DELEGATED DECISION TO DETERMINE APPLICATIONS FOR NON-MATERIAL AMENDMENTS

Reference No: 2025/NM/92784/W

Site Address: Penistone Road/, Rowley Lane, Fenay Bridge,
Huddersfield, HD8 0JS

Application: 2025/92784

2b3p End

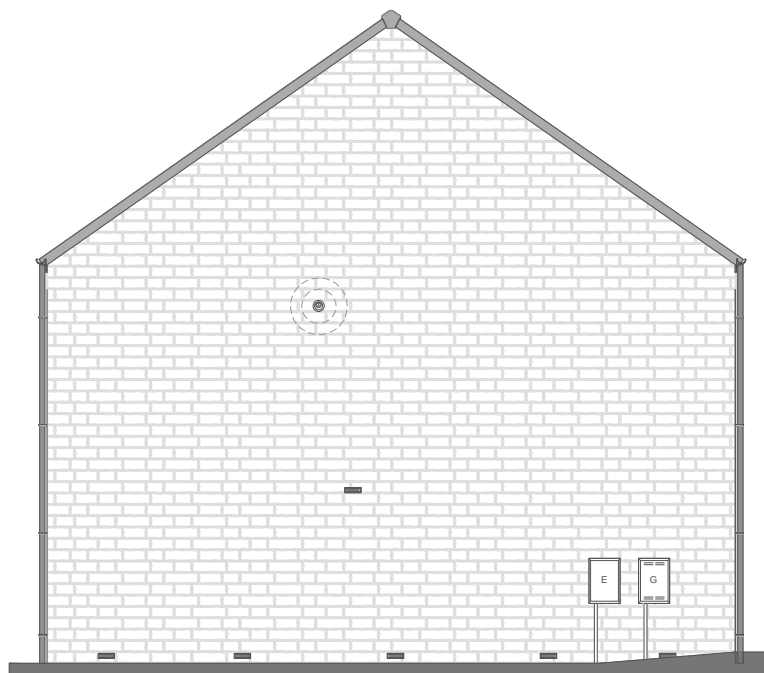
- Updated house types (Avocado and 2B3P), which include a larger window on the ground floor front elevation and revised internal layout.

1. Are the proposed changes inconsequential in terms of scale (magnitude, degree etc) in relation to the original approval? **YES. The location of the window will not change it will simply increase slightly in size in accordance with the revised house type.**

NO. The revised window size is considered to be located sympathetically within the dwelling to ensure it would not detrimentally impact on visual or residential amenity. It would not result in new instances, or intensify, the potential for overlooking. The internal layout is also similar to what was previously approved.
